Re: Objection to MP08_0244 MOD 1 Modification Request for Mixed Used Development at 23-37 Lindfield Avenue and 11 Havilah Lane, Lindfield

As a resident of Lindfield, I/we wish to lodge an objection against the proposed Modification of the subject development based on the following grounds:

ELEVATIONS

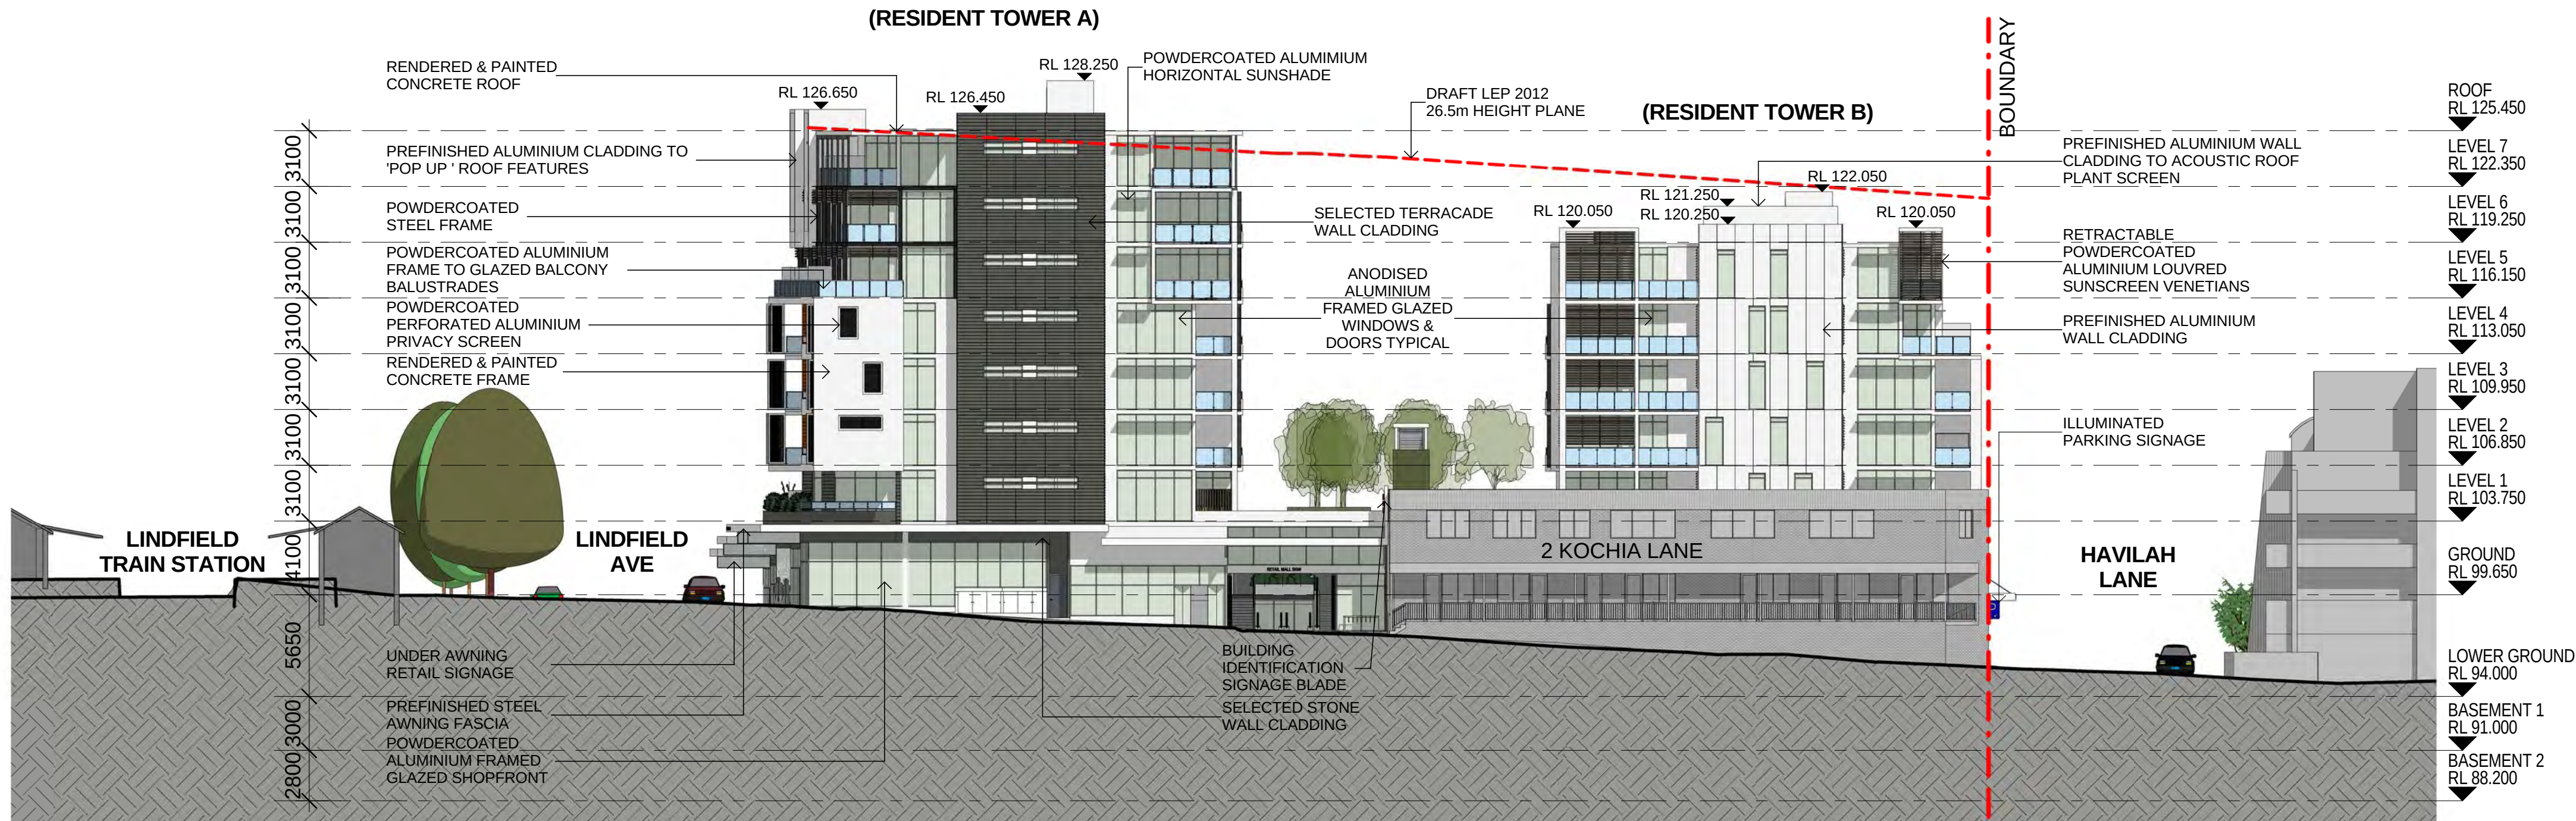
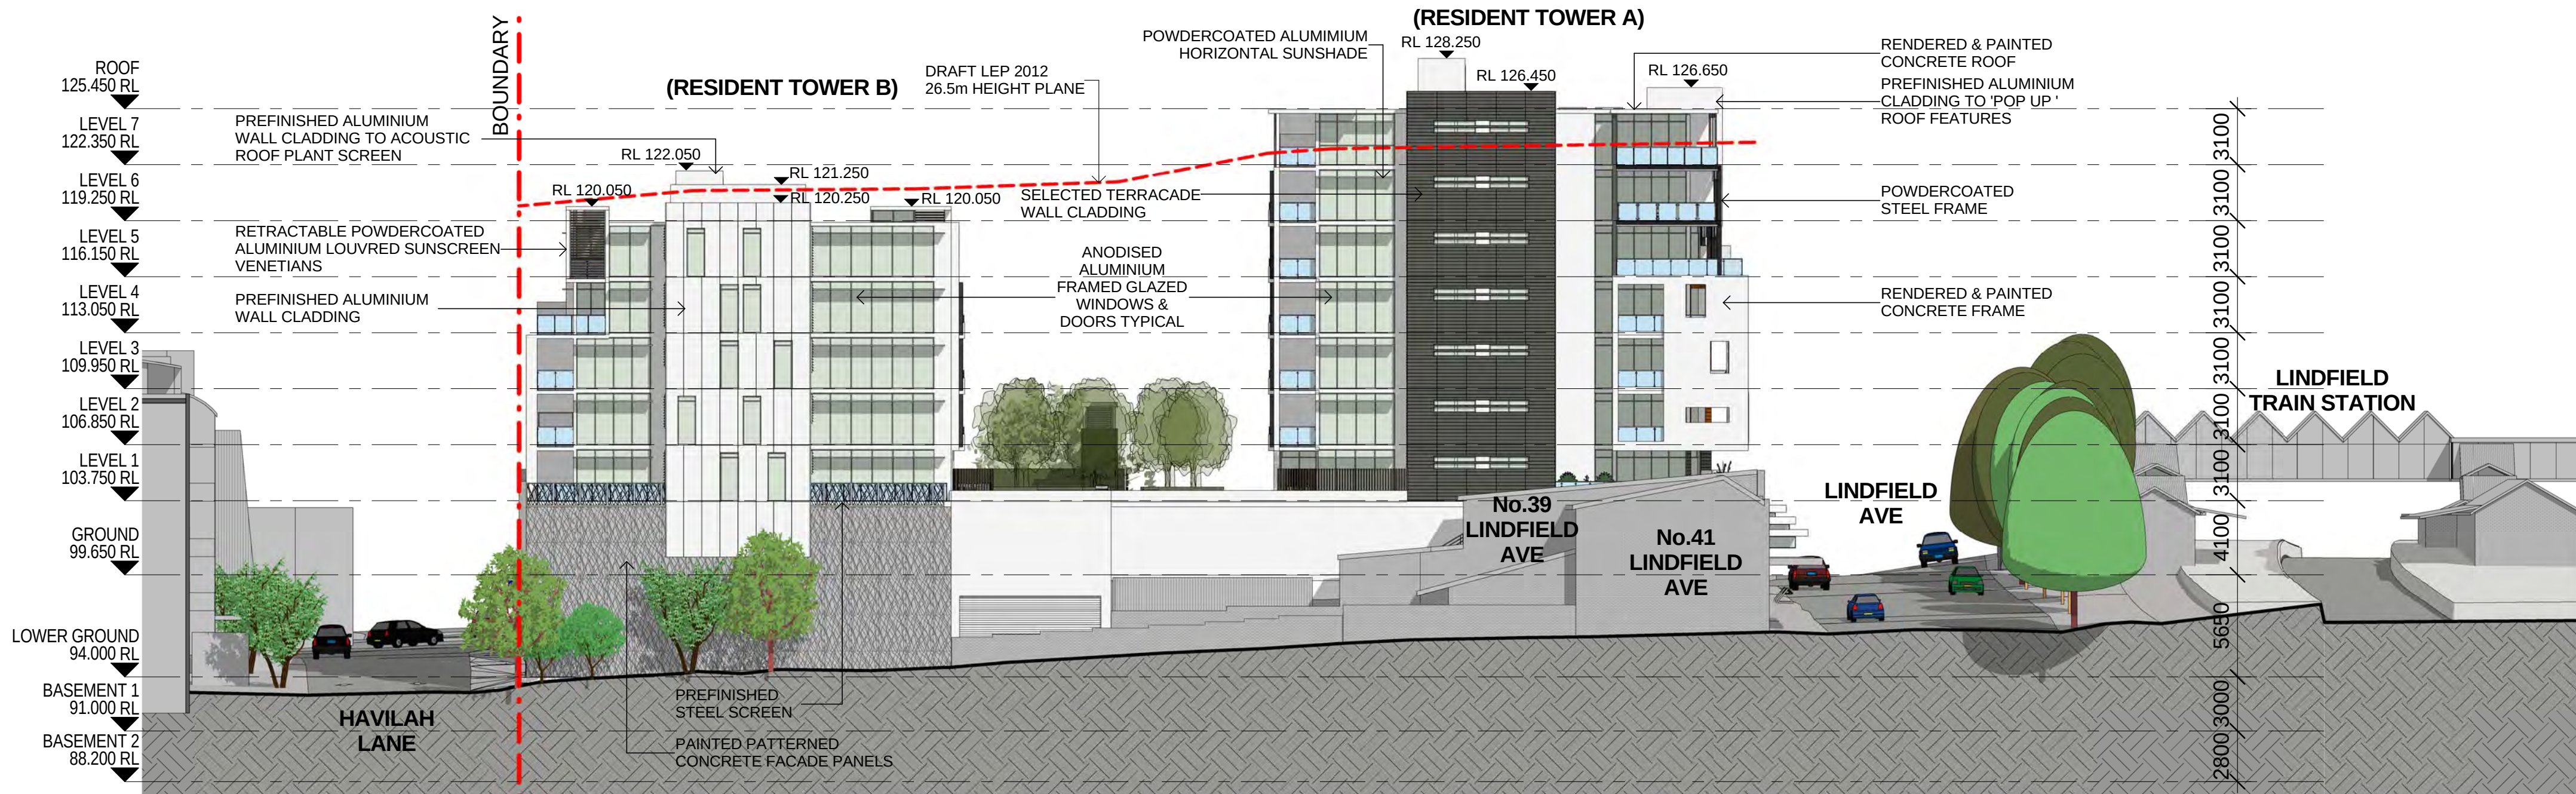
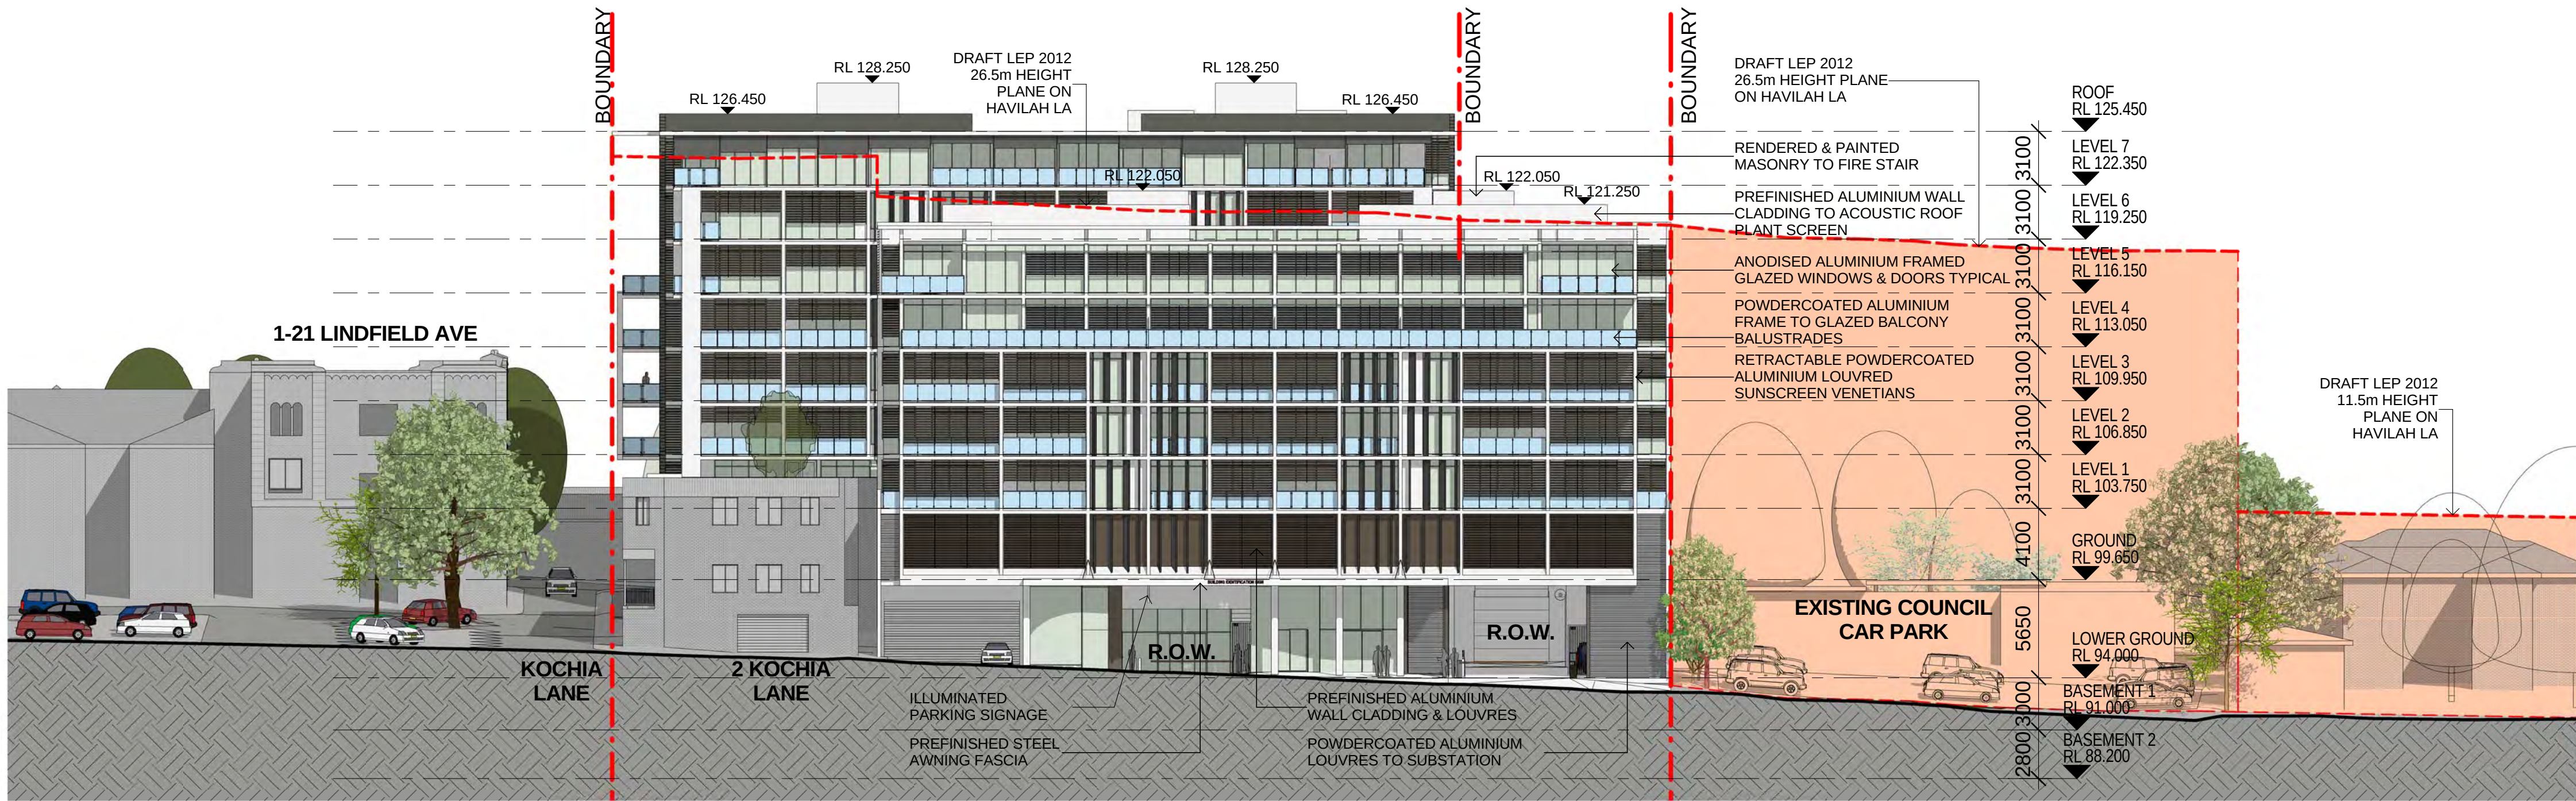
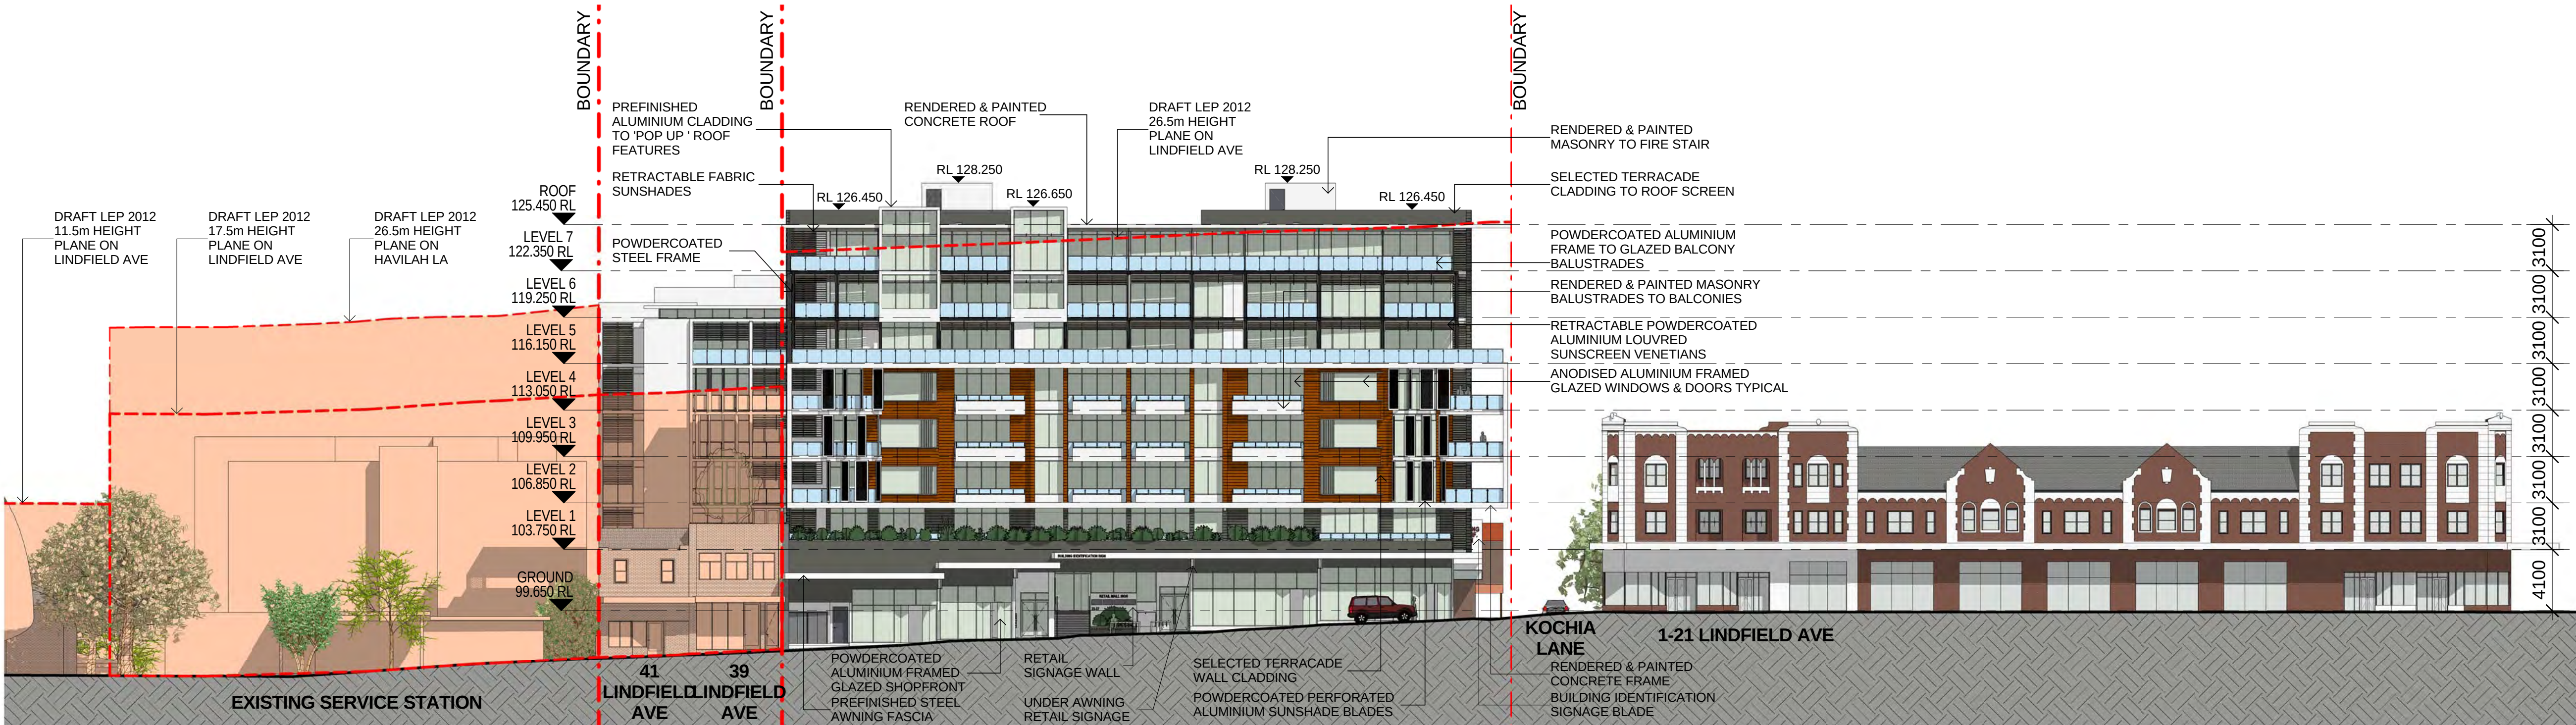
- The increase of an additional storey to both buildings: 8 storeys on Lindfield Avenue and 7 storeys on Havilah Lane creates excessive height and bulk and is out of character with the surrounding buildings, including the heritage listed adjacent building on Lindfield Avenue

- The additional storey (combined with less set back than the approved design) on Havilah Lane now creates privacy concerns for over 40 apartments in the adjacent 8 Havilah Lane, 8 Kochia Lane and 2-8 Milray Street residences
